From: Andrew Gayler
Sent: 10 May 2012 11:36
To: Planning.Responses
Cc: Jim Henn; Anita Gardner
Subject: RE: Please find attached amendment on planning application Ref: FG/6/12/

APPLICATION FG/6/12/

Site The Old Barn Ferringham Lane Ferring BN12 5LL

Description of Works: Change of use of the Old Barn, Annexe building & warehouse from (A1) retail to 2 no. 3 bed residential dwellings (C3 dwelling houses)

The Annex - Proposed Ground Floor

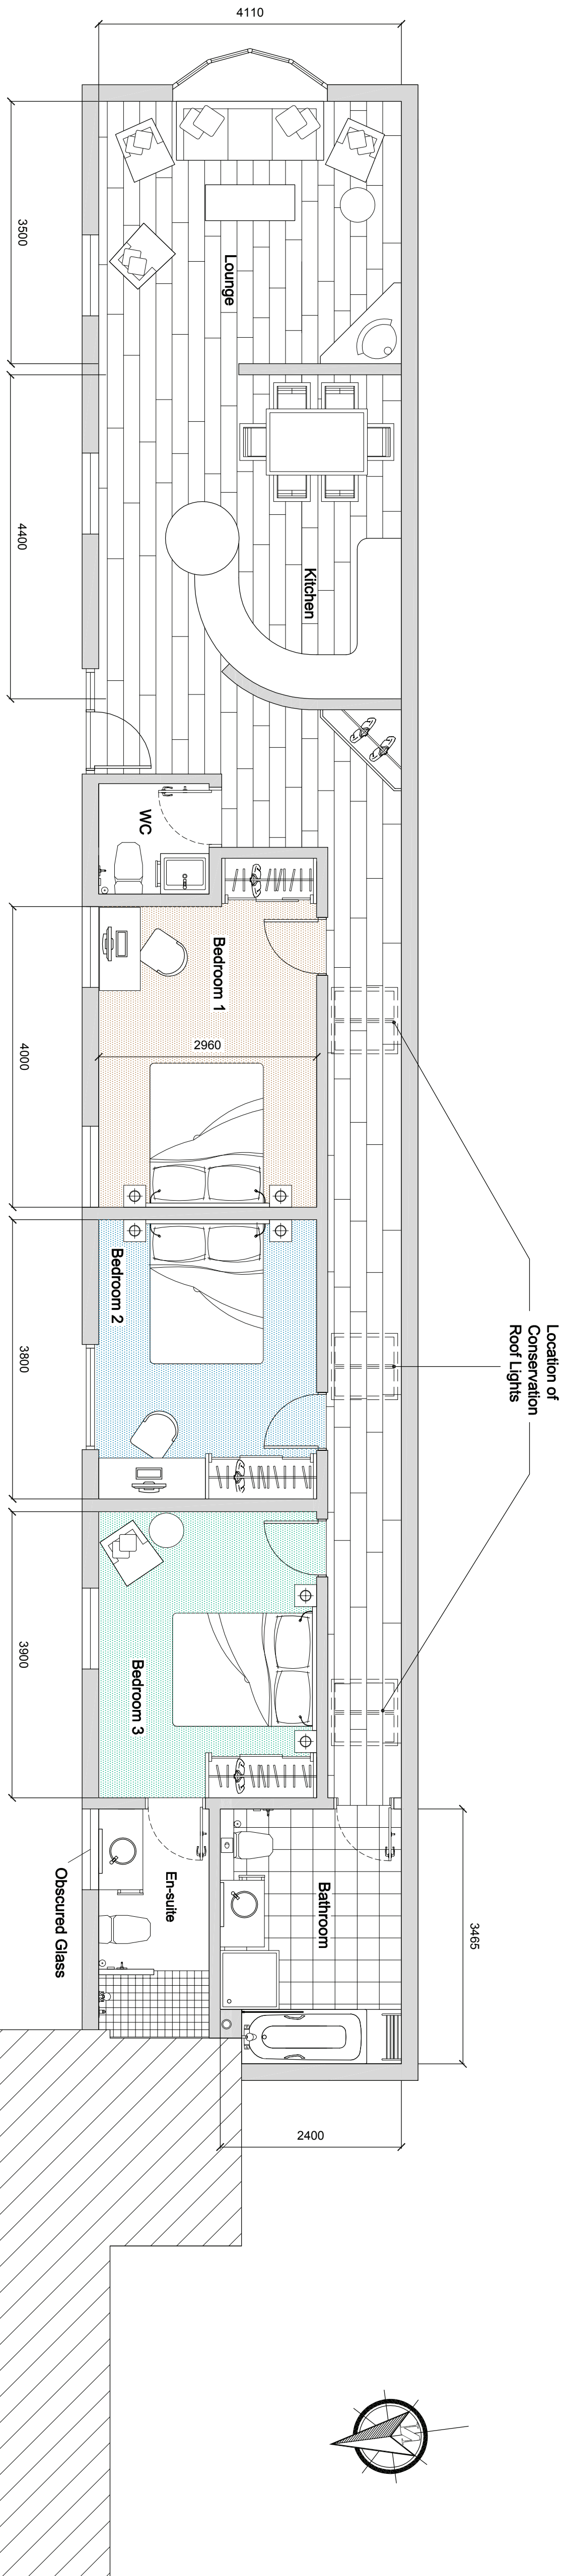
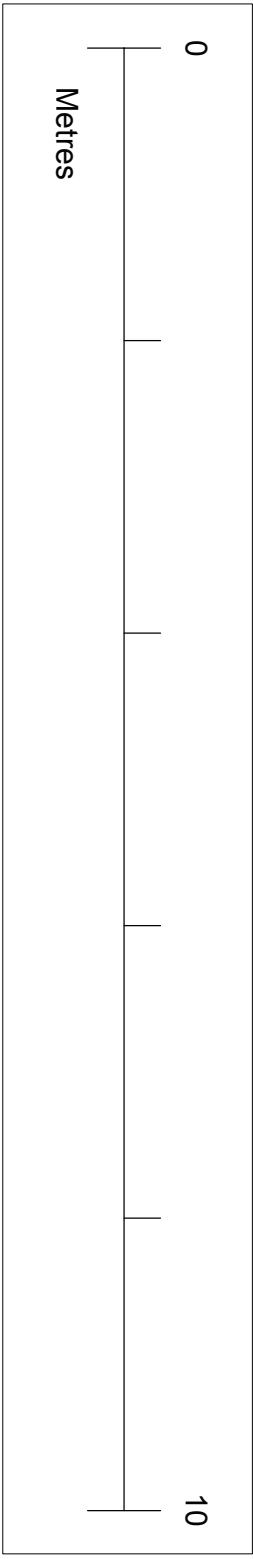
- Emergency egress windows are also required to bedrooms 1, 2 and 3 of the Annexe building.

The Old Barn - Proposed Ground & First Floor - GA

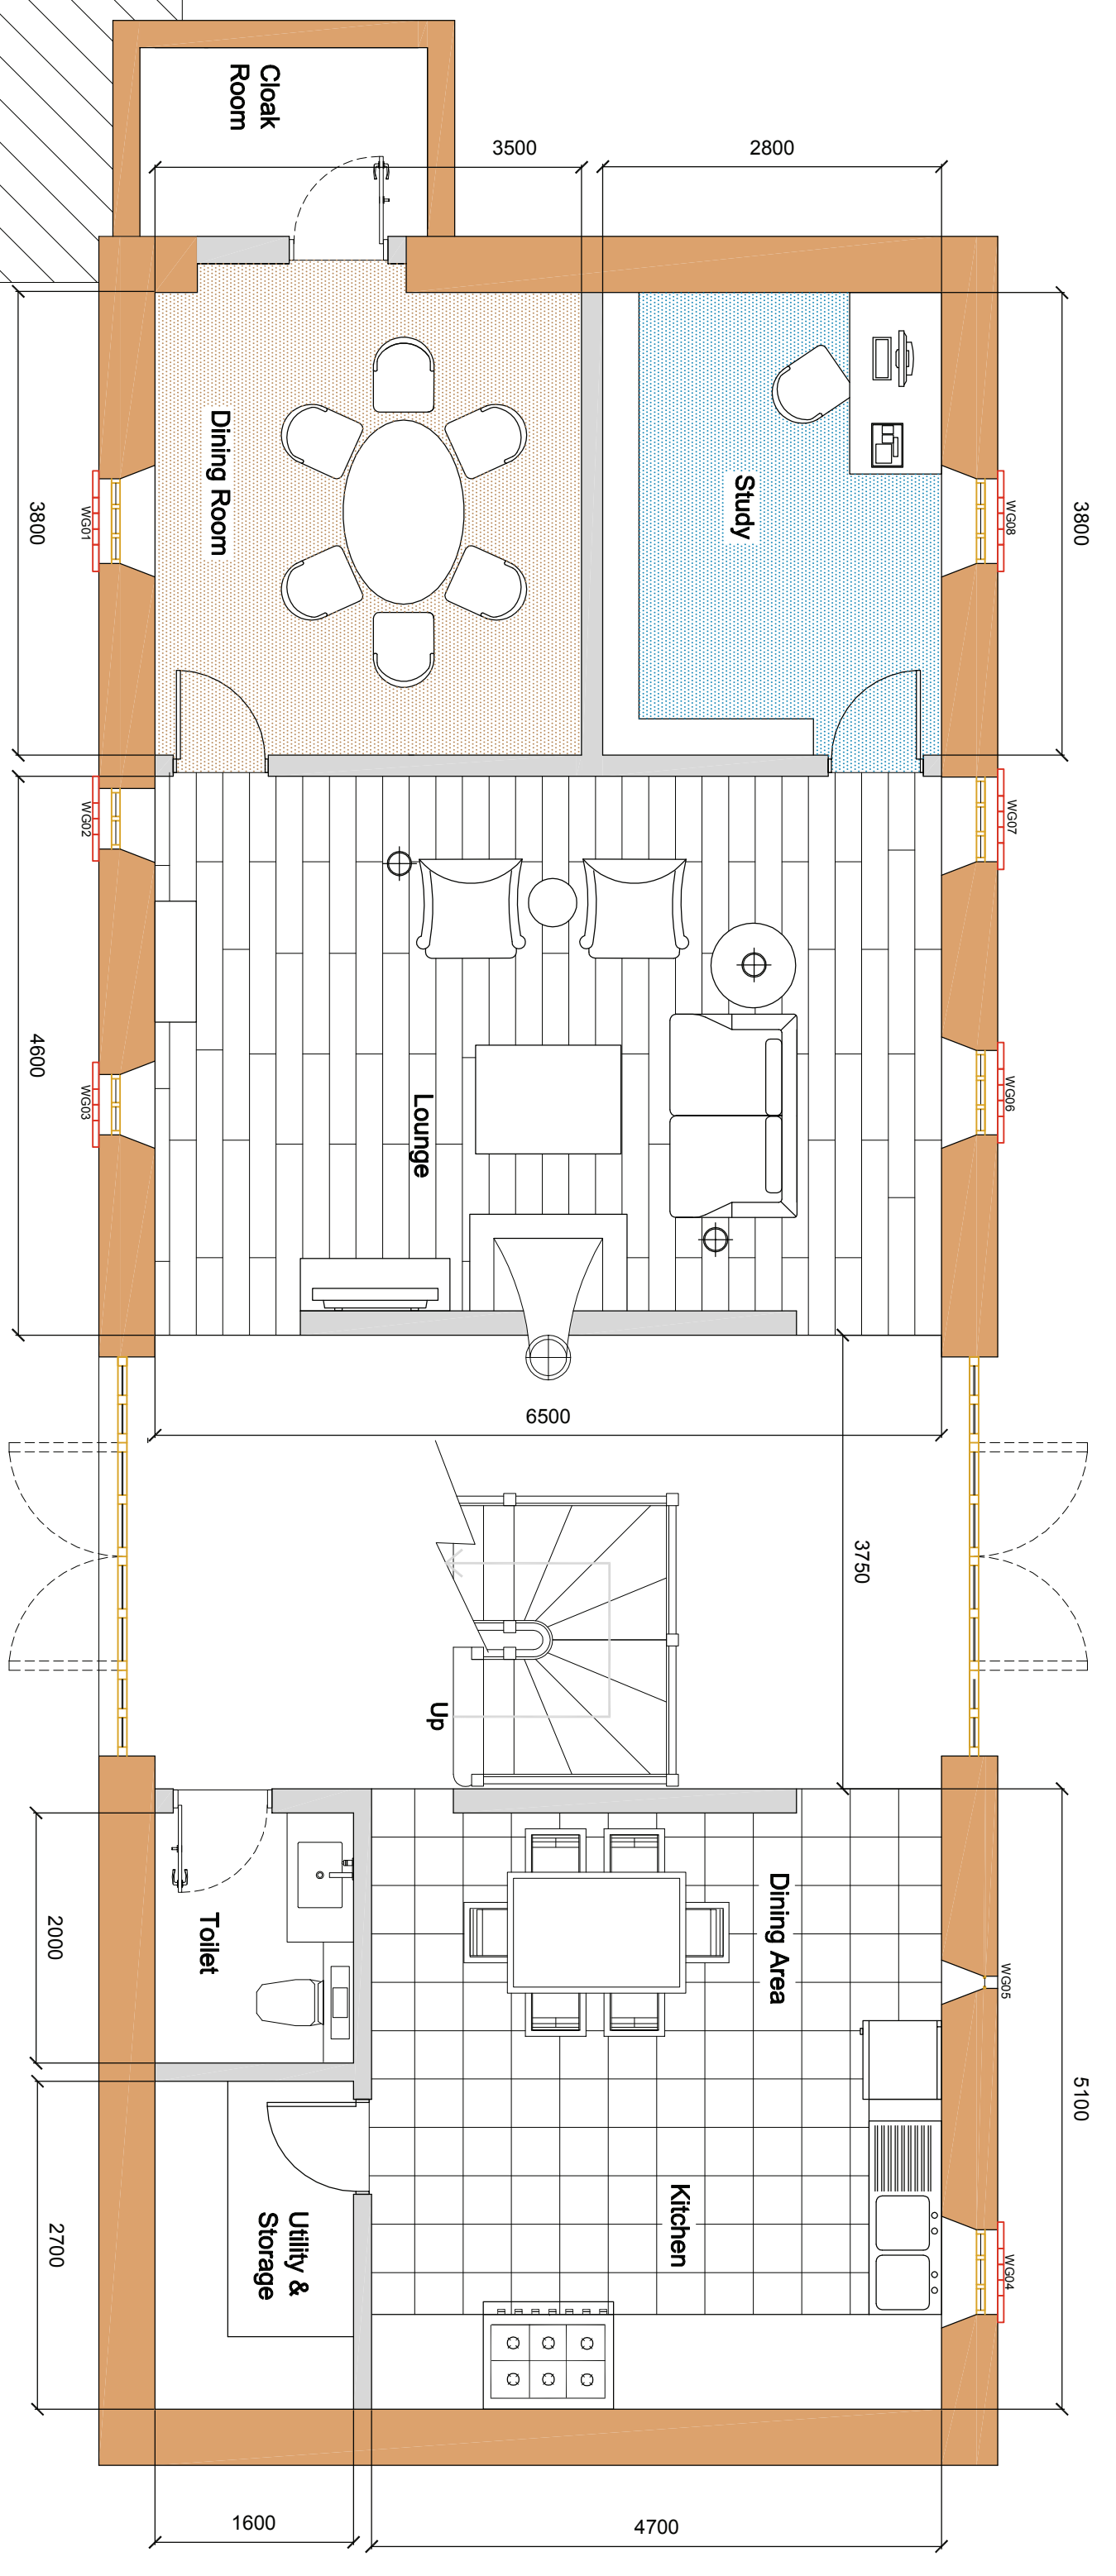
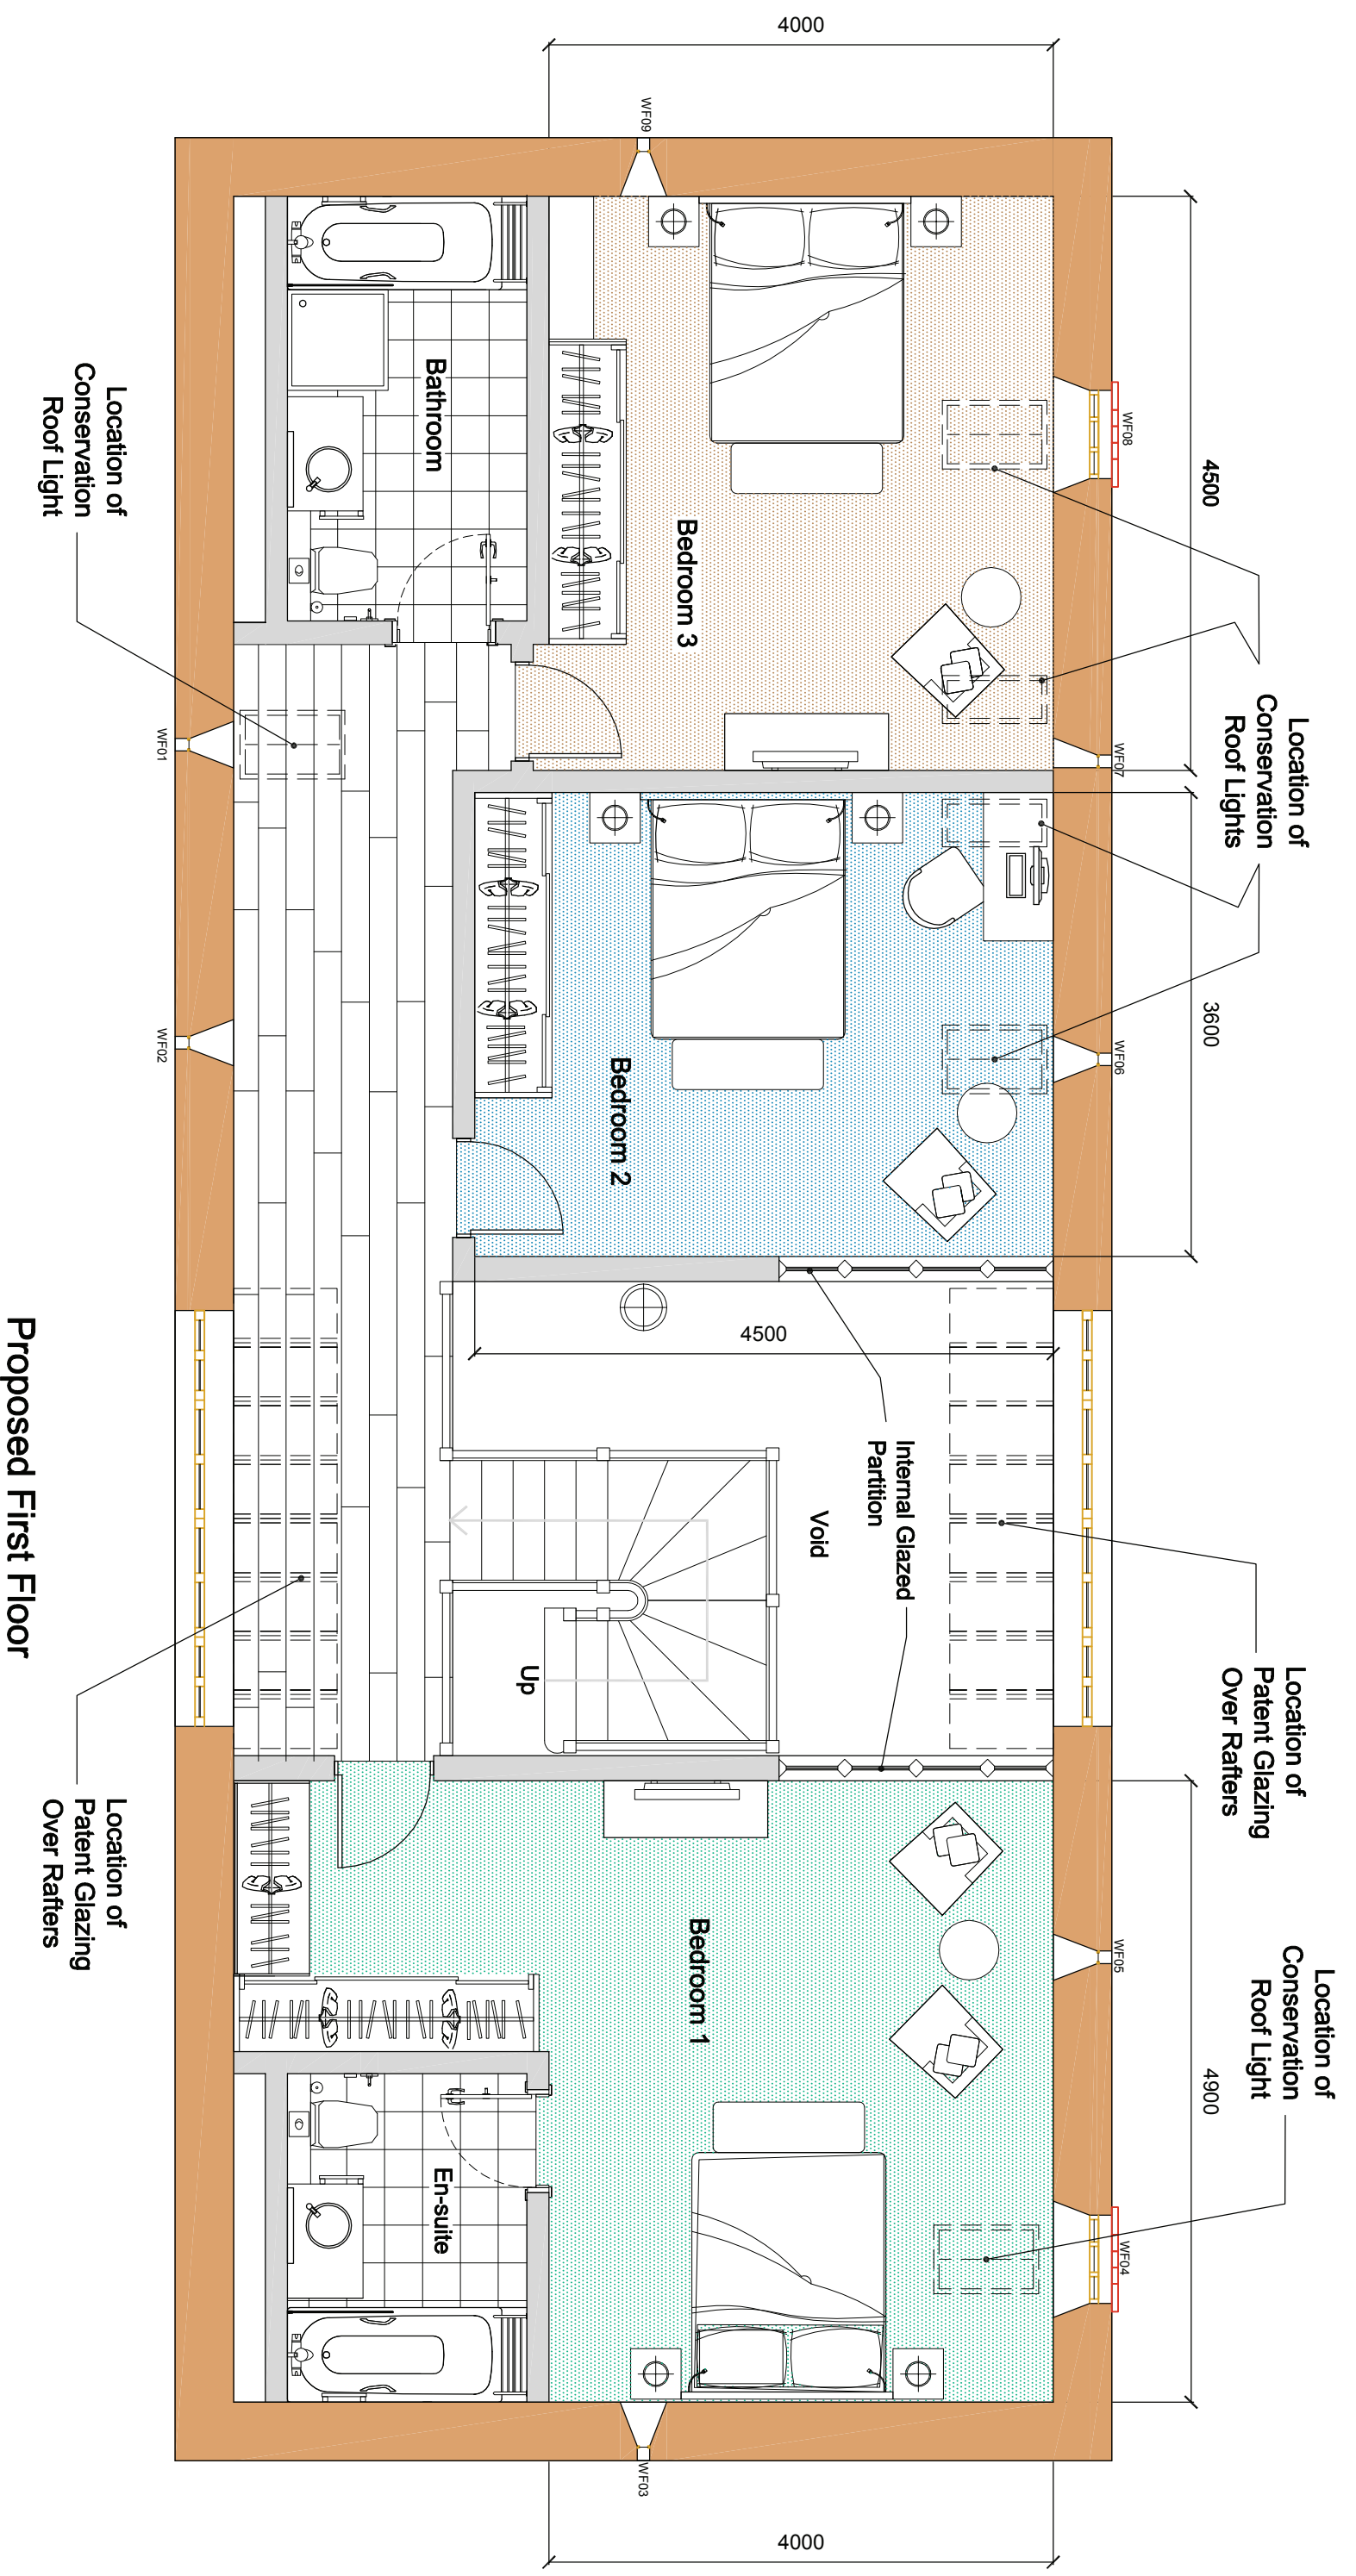
- Emergency egress windows would typically be required to the study and bedrooms 1, 2 and 3 of the Old Barn, these windows require a minimum clear opening of 0.33m² with no dimension less than 450mm and should be positioned between 800-1100mm from floor level. Due to the proposed open plan arrangement it may be necessary to consider an alternative approach, the Agent may wish to consider paragraphs 0.16-0.18 of Approved Document B - Fire Safety (Volume 1 - Dwellinghouses) which gives guidance on the use of residential sprinklers where the provisions of the Approved Document are to be varied.
